Ref Planning Application 2023/93667

Further to my earlier letter which outlined objections at the time, I would like to raise additional points following the release of new documents from the applicant.

Northern Site Access

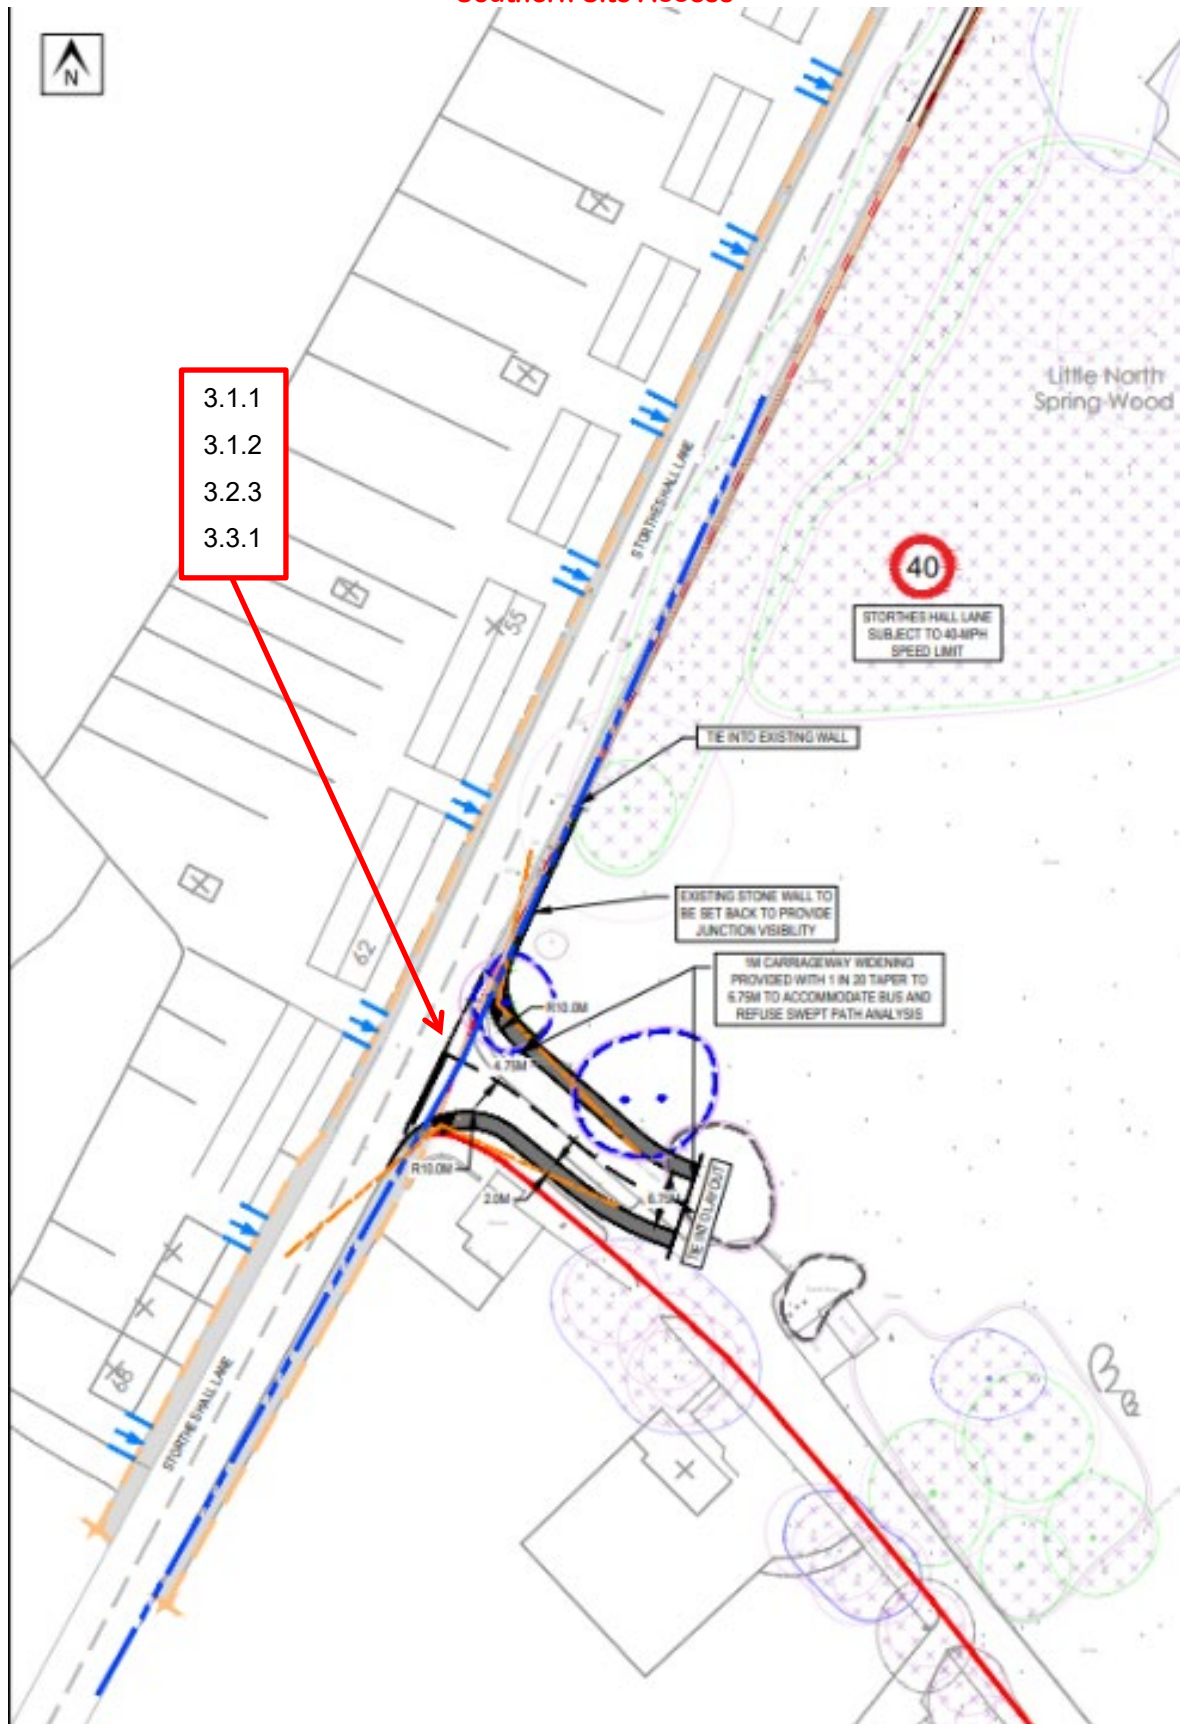
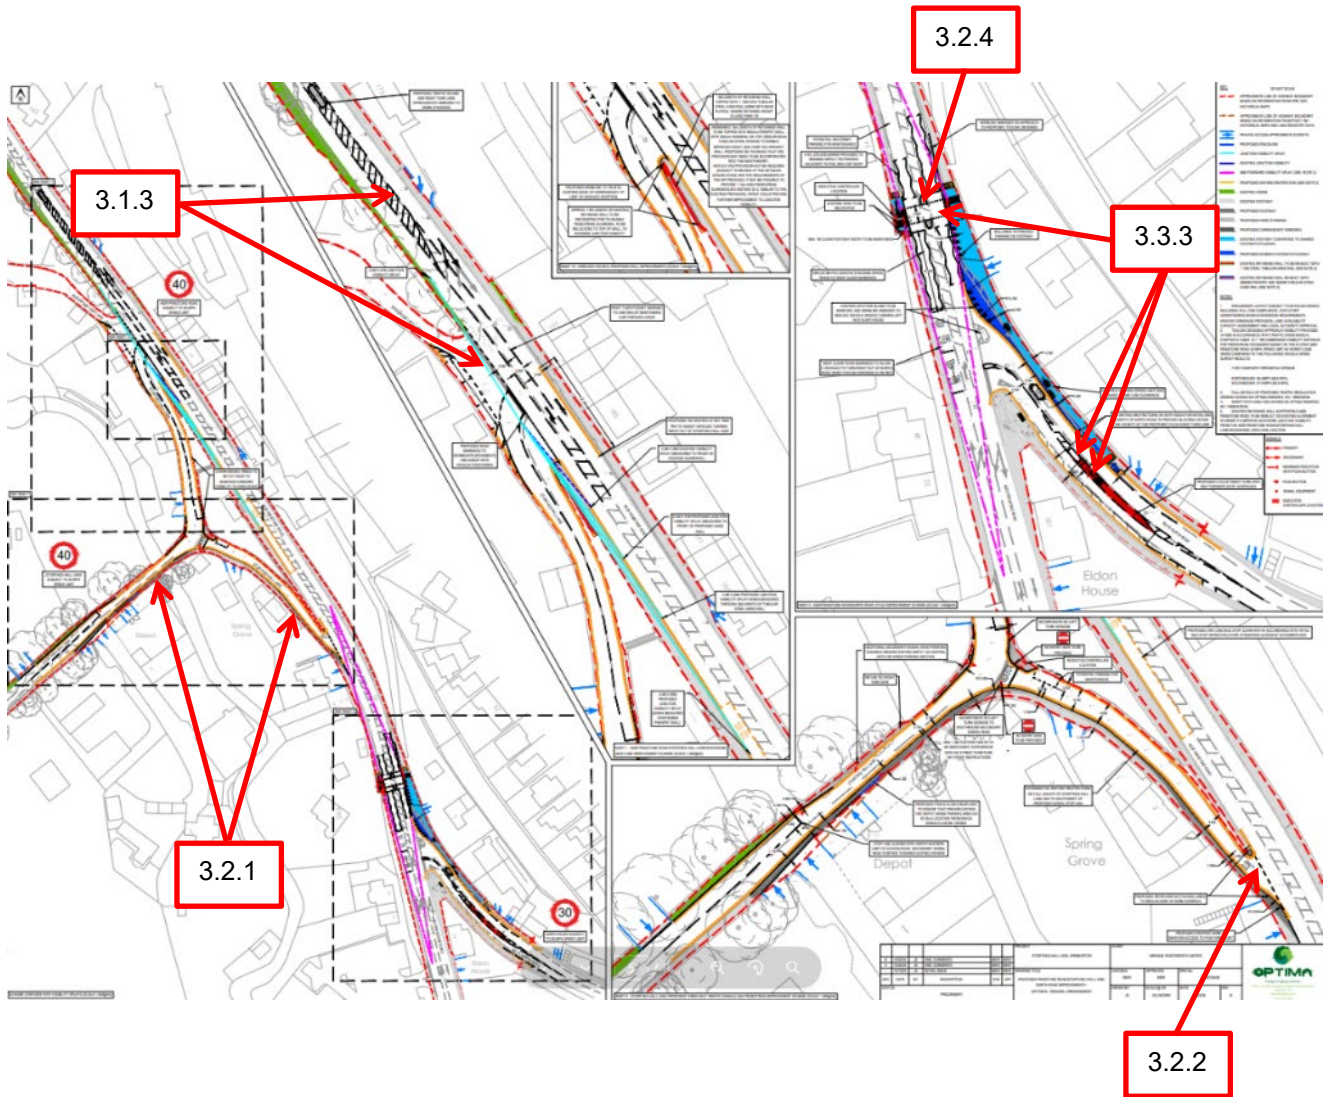
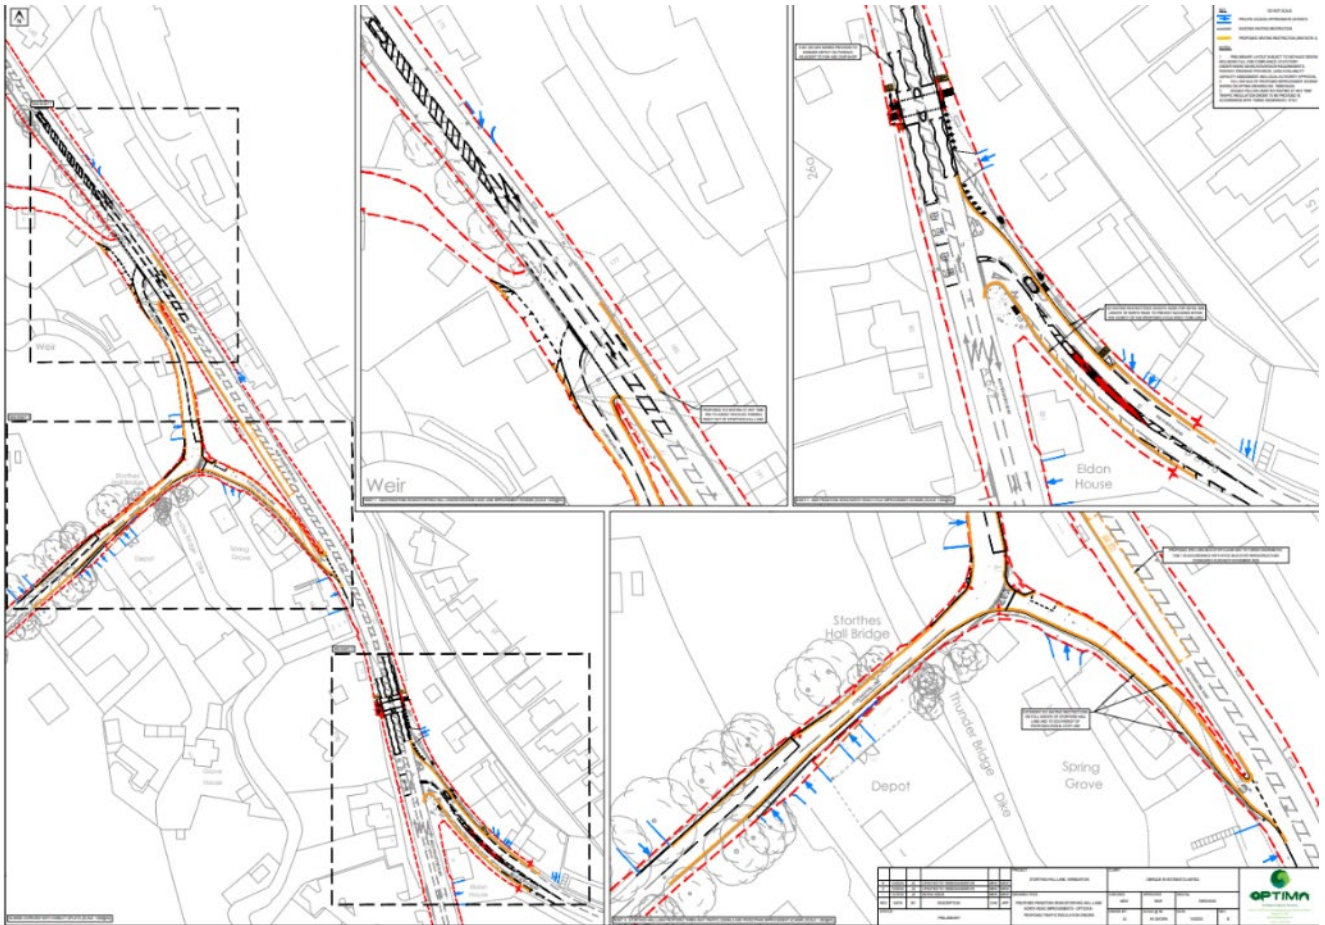
The traffic proposal for the junction with Penistone Road seems to be largely unworkable and does not take into account how this will impact upon local residents or businesses.

There are 3 local businesses in close proximity to the bridge, which under the new proposals will be traffic light controlled. All of these either operate large vehicles or have deliveries/collections by large vehicles. The plant business operates 28t tipper trucks and articulated lorries, the lighting business has deliveries from articulated lorries as does Loading Systems.

I foresee traffic chaos as soon as traffic lights are introduced into this environment, with a traffic backlog both up Storthes Hall Lane and onto Penistone Road.

There are also a number of large tractors with trailers that service the fields at the top of Storthes Hall Lane that use the bridge and are wider than ½ the road. There is a depot for road chippings below the lower access gate to Storthes Hall Park which has deliveries and collections by 40t 12-wheel lorries. As witnessed only this week, these vehicles also take over ½ the road available to cross the bridge.

The suggestion to narrow the bridge to allow for a pedestrian walkway doesn't seem to have taken into account the size of vehicles that use the bridge.

Neither has the current width of the road from the bridge to the junction with Penistone Road look to have been increased. There are several points on this stretch that are narrow and if there is going to be traffic held waiting for lights to change, vehicles coming in the opposite direction are going to be unable to pass. Another opportunity for traffic to back up in both directions.

The proposal to introduce double yellow lines from the junction with Penistone Road all the way to just before my gates and past Jones Lighting doesn't seem to take into account the residents of either Penistone Road or Spring Grove. At times at least 9 cars have been counted parked in these areas with others parked on Penistone Road outside houses. Where will the additional cars park when spaces are limited?

They will be unable to park further along Penistone Road due to the proposed toucan crossing and zig zag lines. The reduction in car parking spaces in this area will have a negative impact on Spring Grove Fisheries as will the introduction of double yellow lines on the entrance to North Road.
